**Consultation Response from KC,
Lead Local Flood Authority**

2025/90372 Land at, Edgerton Road, Edgerton, Huddersfield, HD3 3AA

Discharge of details reserved by conditions 6, 7, 8, 9 (drainage), 11 (lighting scheme), 14 (Arboricultural Method Statement), 19 (Construction Method Statement), 21 (estate road), 22 (highway works), 23 (boundary treatments) on previous permission 2017/91916 for variation condition 23 (highway works) on previous permission 2014/93014 (APP/Z4718/W/15/3002523) for outline application for residential development comprising of 41 dwellings plus associated works (within a Conservation Area)

Date Responded: 3rd August 2025

TYPE C CONCRETE MANHOLE - SECTION VIEW
FOR DEPTHS TO SOFFIT LESS THAN 1500mm

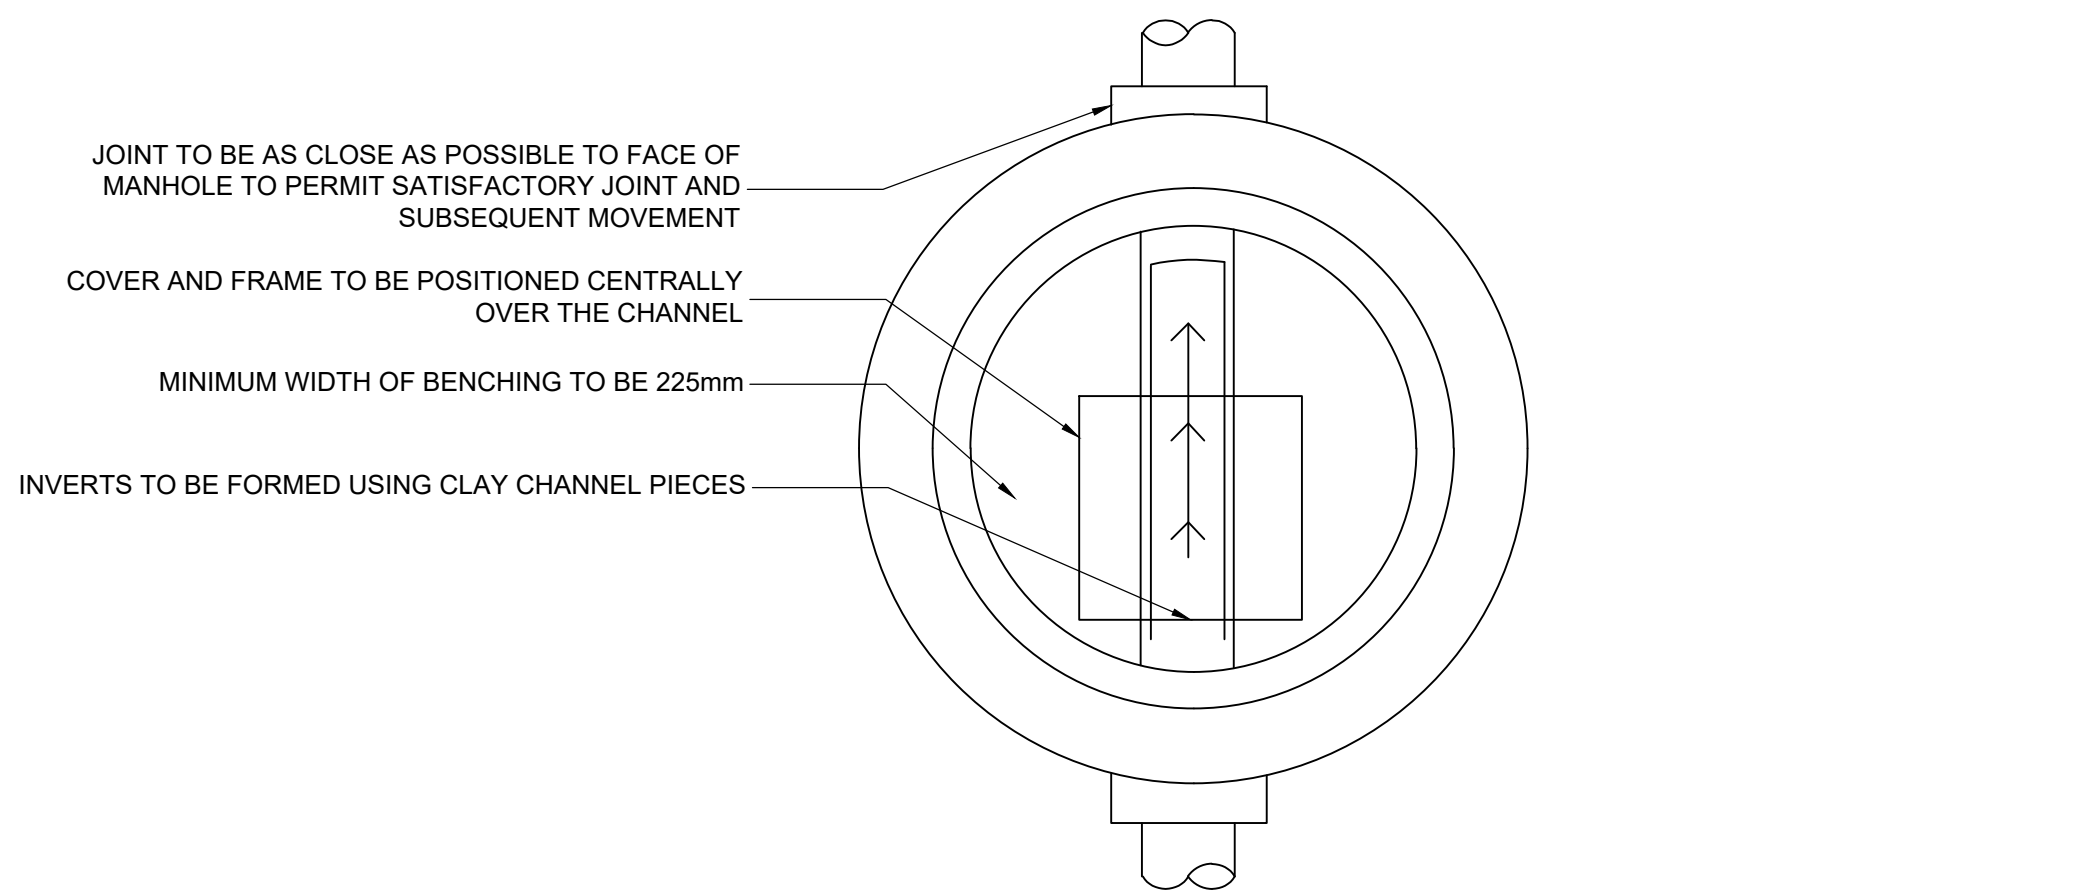
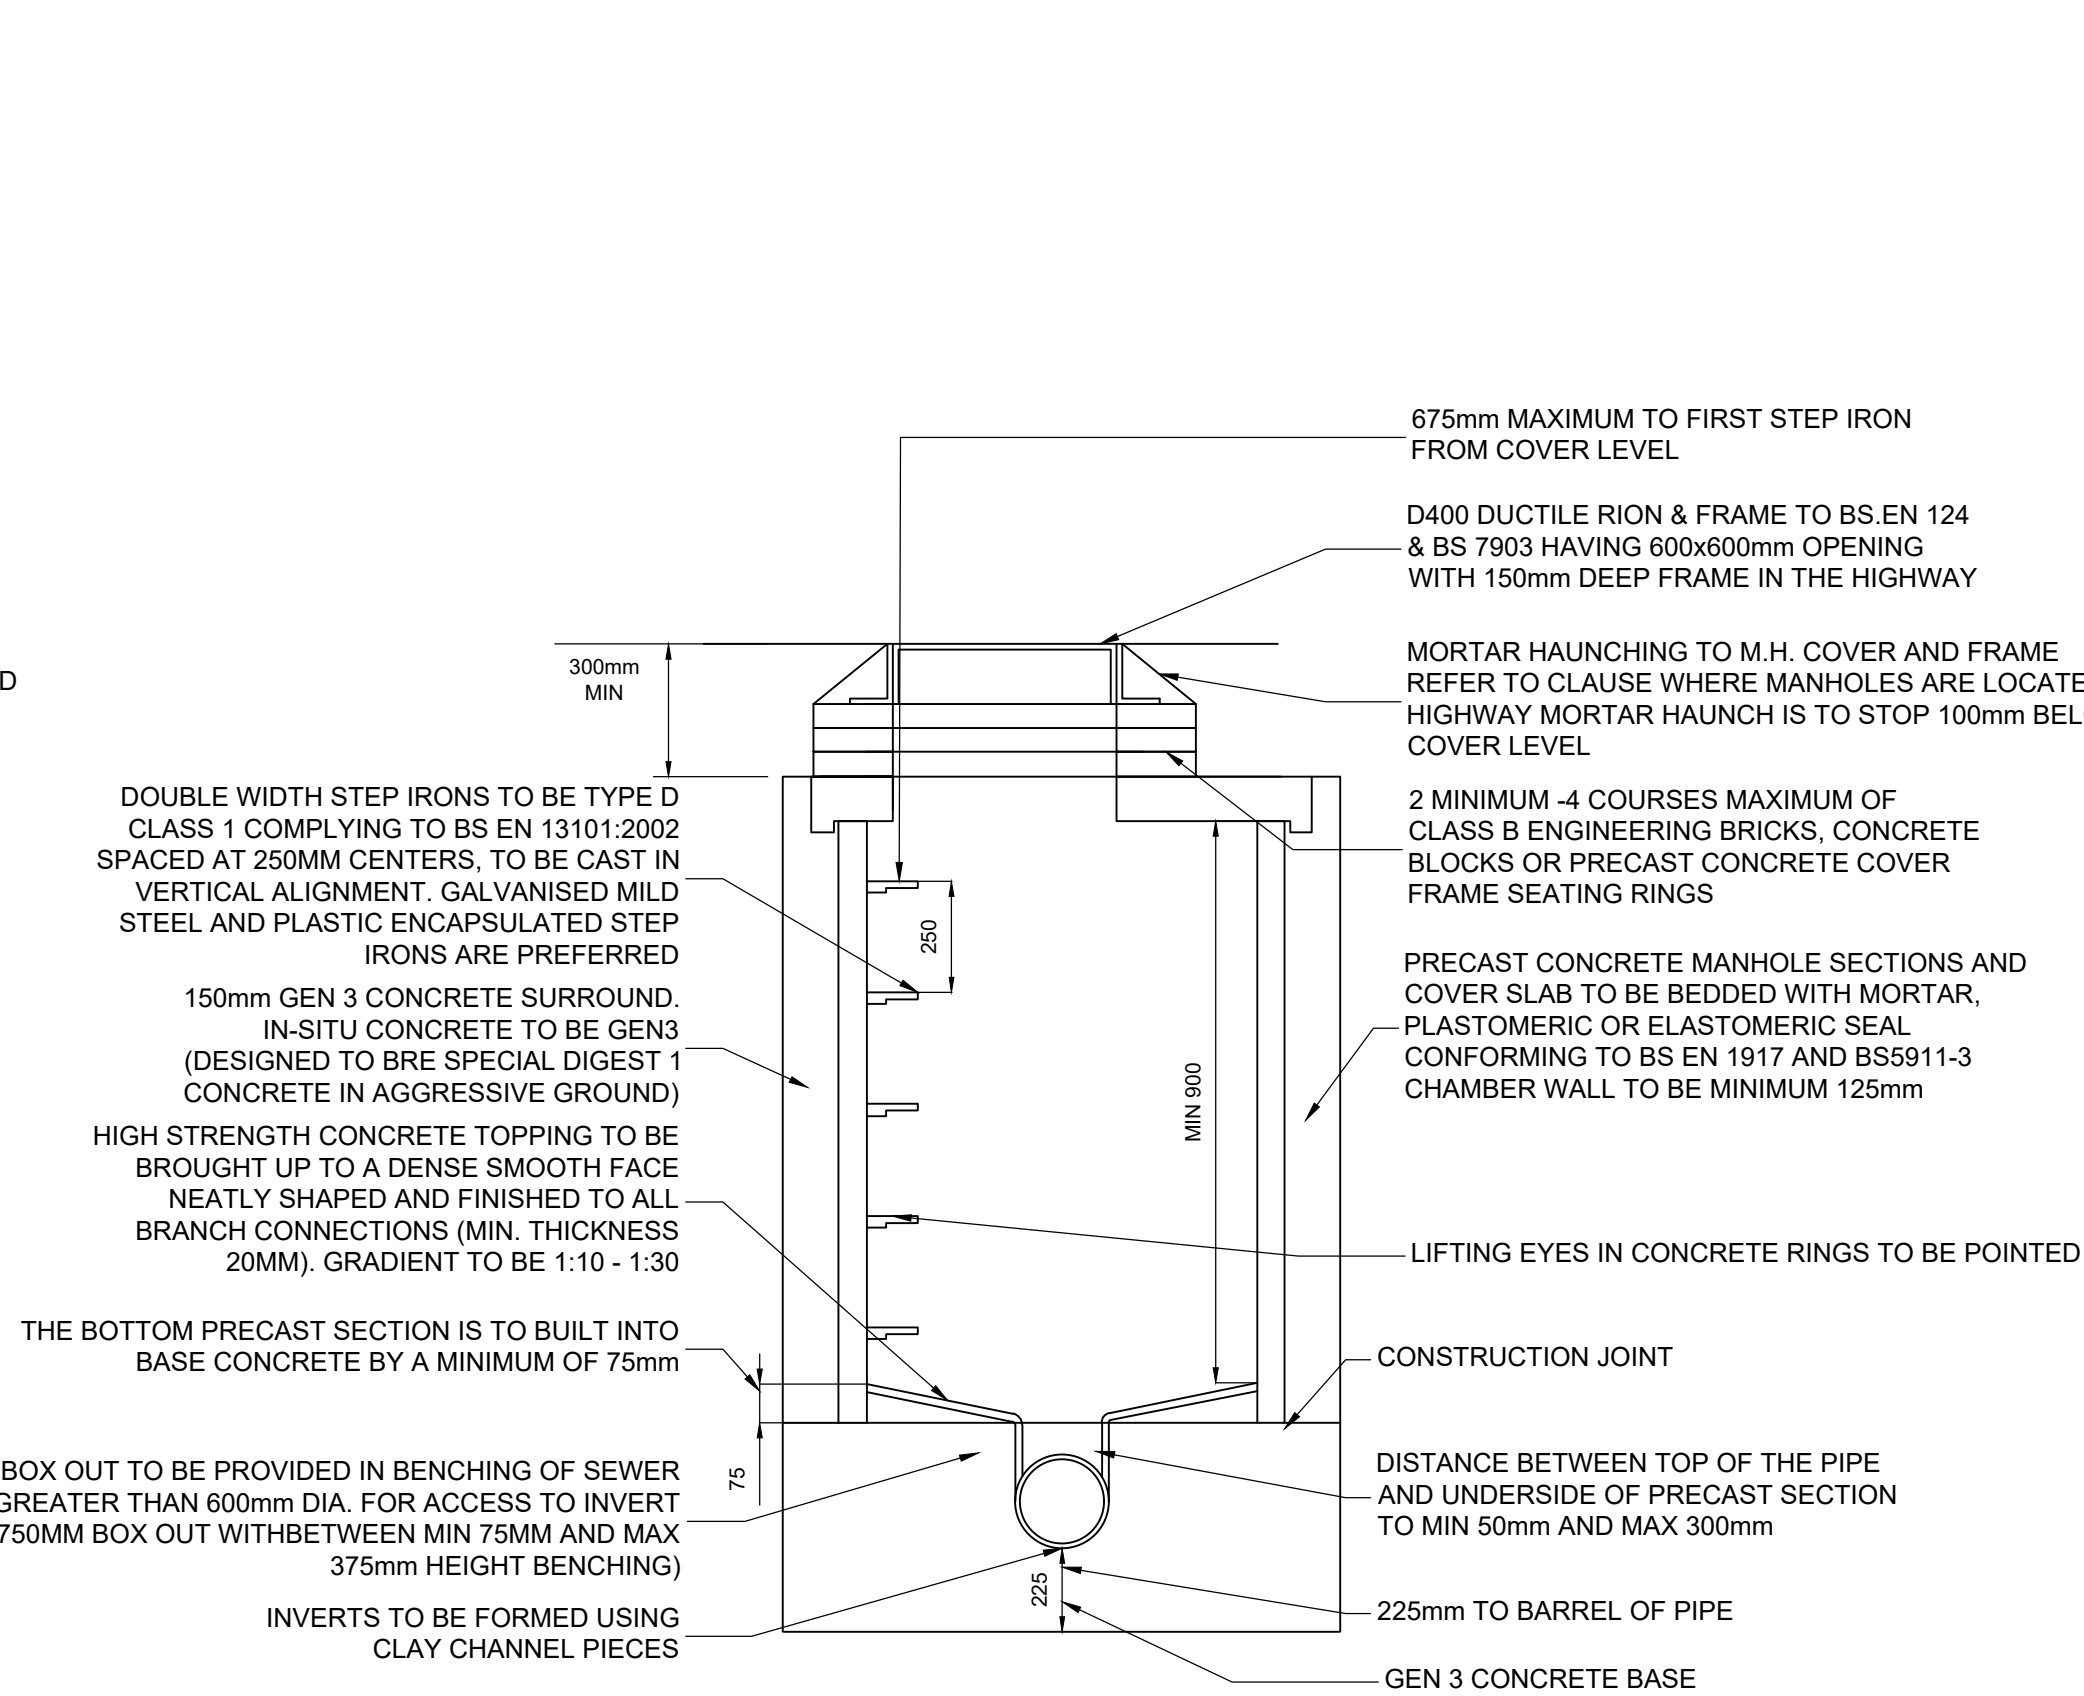
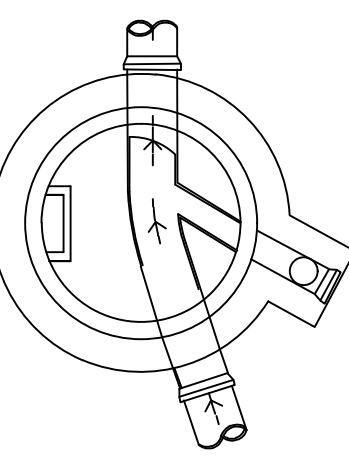
There are no detailed drawings of the tanks, cross sections, plans, manufacturing type etc. No flow control manhole details have been submitted. No flow control designs have been submitted.

There are no updated longitudinal sections, and the original ones do not show pipe sizes or indicate where backdrop manholes are located.
